**Re: Objection to Planning Application 2025/92799 – 26 Inglewood Avenue,
Huddersfield. HD2 2DS
(Cont'd)**

Please find below supplementary relevant images supporting our objection dated 17/11/25 against the above:-

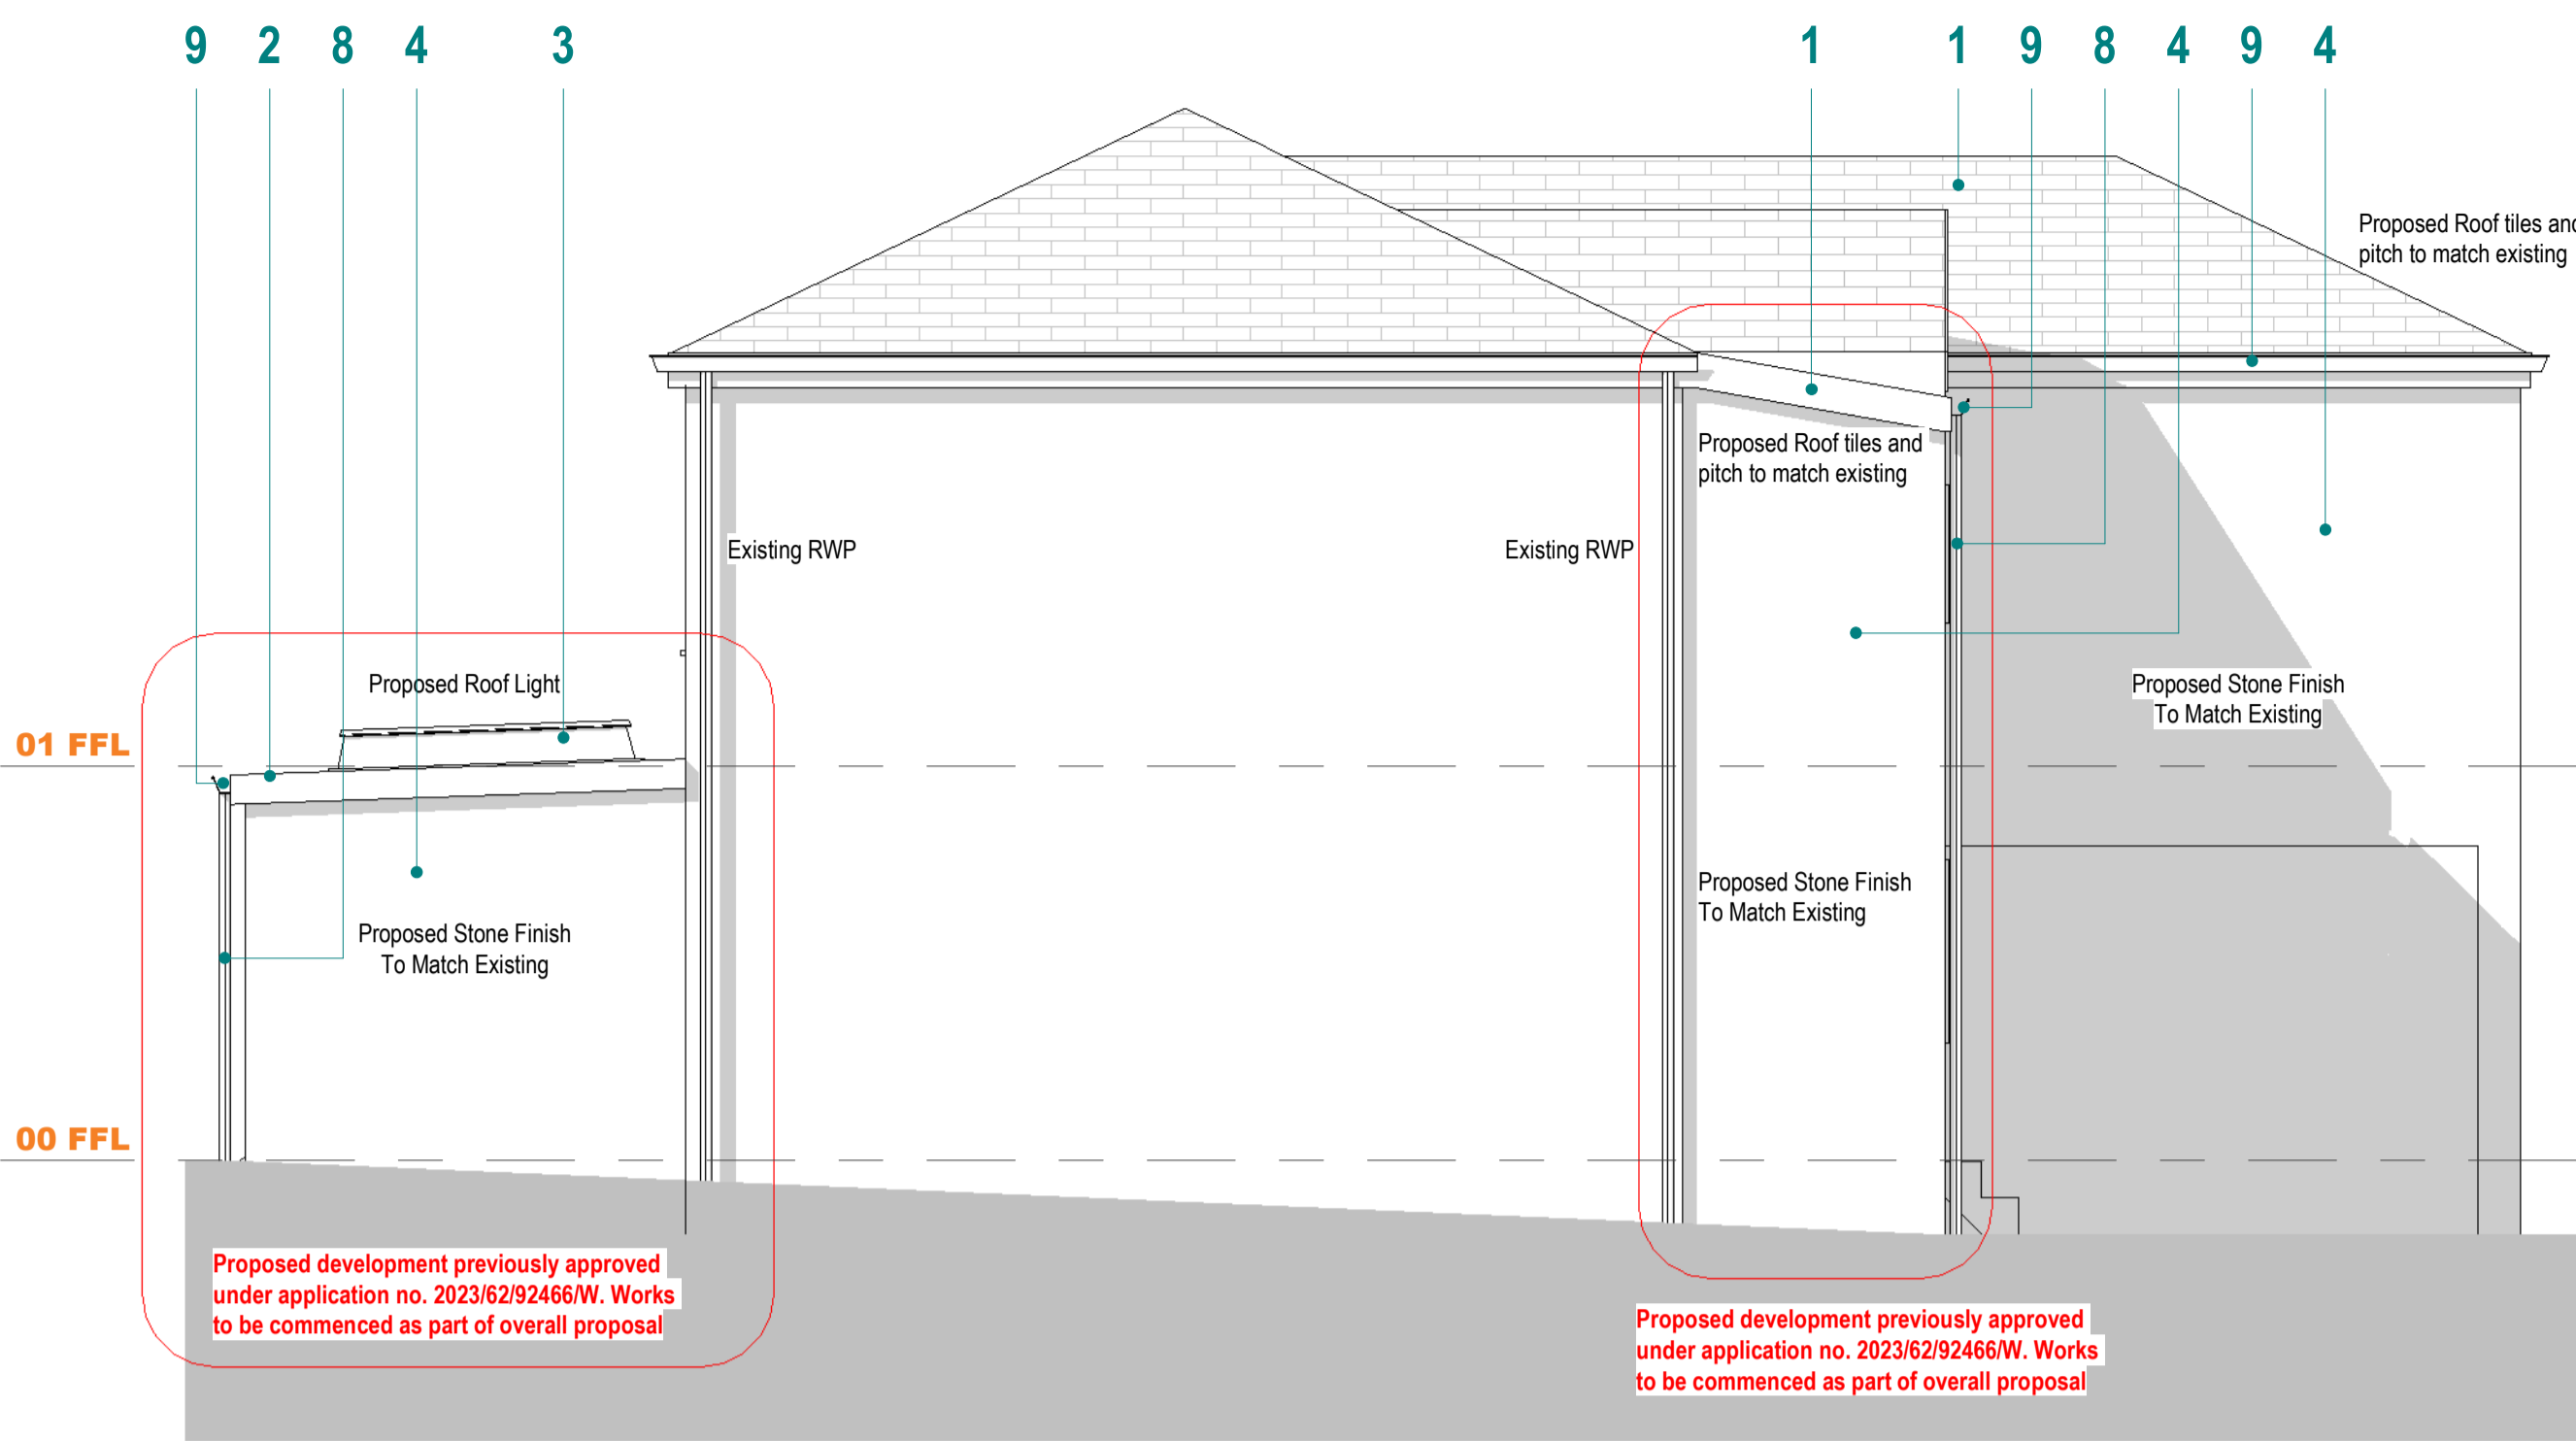
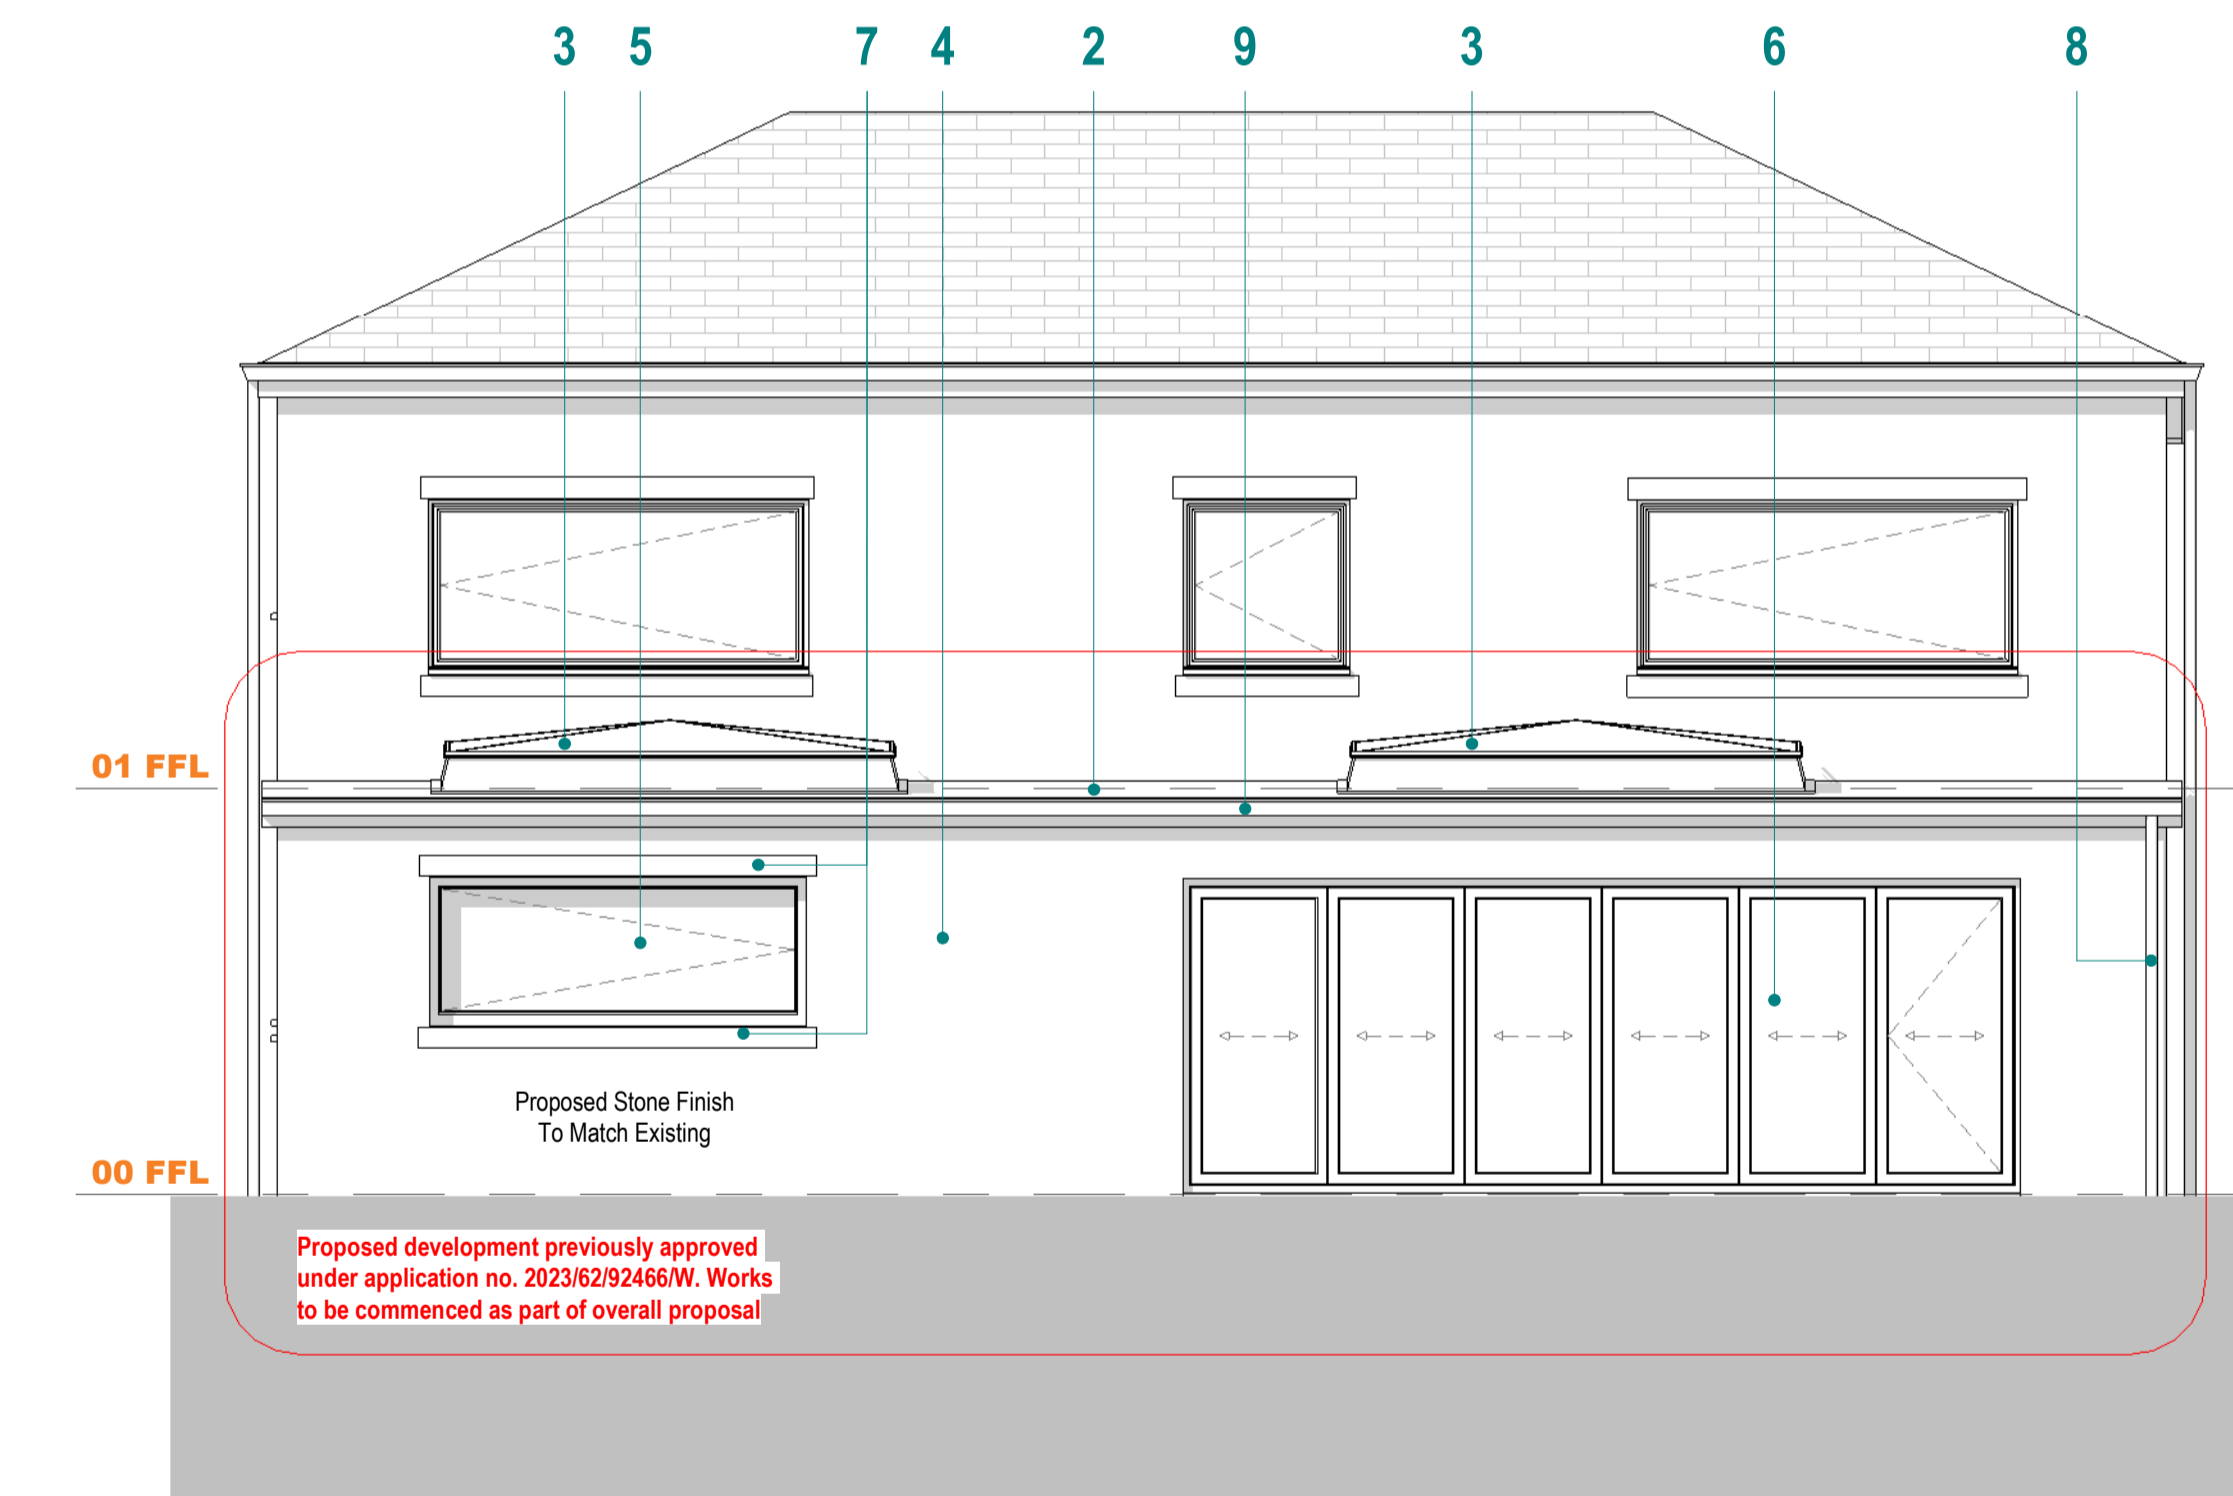
However, the proposed garage door alteration to a clear window and the extension also with a clear window will significantly reduce privacy.

Also they will overlook front garden, entrance path and driveway.

However, the natural light will totally be blocked off by the extension!
